TOWN AND COUNTRY PLANNING ACT 1990 FULL

Reference: H11-1294-25 **Date of Decision:** 20th March 2026
Applicant: Mr & Mrs J Heading
4a Gimmels Gate
Long Sutton
Spalding
Lincolnshire
PE12 9AS
Location: 4a Gimmels Gate Long Sutton Spalding
Description: Change of Use of Storage Shed to Residential - Retrospective

Rev.	Description	Date
HEAL PLANNING APPEALS		
Hooper Enterprise Associates Ltd St. Mary's Place, Shrewsbury, Shropshire, SY1 1DZ.		
Project: 4a Gimmels Gells Long Sutton Spalding		
Title: Elevations and Plans		
Date:	Nov 2025	Drawing No:
Scale:	1:100	HP-GGL-02
Copyright © 2025 Heal Planning Appeals

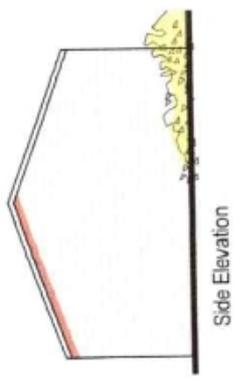
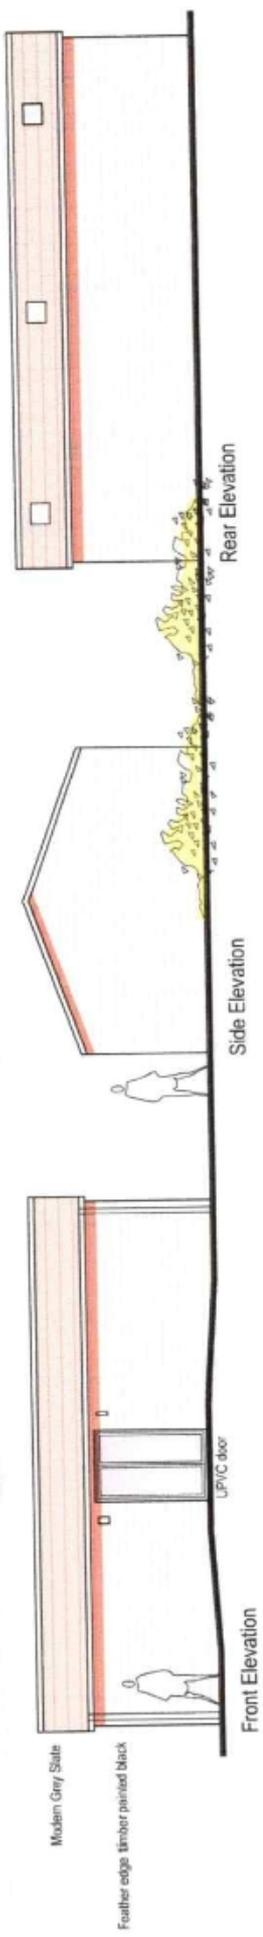
- 2 The resultant development would provide approximately 48sqm of internal gross floor space, and the submitted layout plan fails to demonstrate the provision of a bedroom within the proposal, illustrating a kitchen, bathroom, living space and storage space only.

Given that the submitted plans fail to illustrate the provision of any bedrooms, the proposal fails to evidence that this requirement is met.

Furthermore, the proposal site lies within Flood Zone 3 and within a hazard classification of 'Danger for Some', with a peak flood depth of 0.25m. Notwithstanding the submitted Flood Risk Assessment stating that the floor level of the development has been raised to a minimum of 400mm above existing ground level, neither the submitted plans nor the photographs demonstrate or evidence this to be the case.

As such, it has not been evidenced that level of works that would be required to achieve the necessary flood mitigation to ensure that the scheme exceeds the flood depths and therefore is safe for its lifetime, could be achieved without the resultant floor to ceiling height falling below the 2.3 metres required under the nationally described space
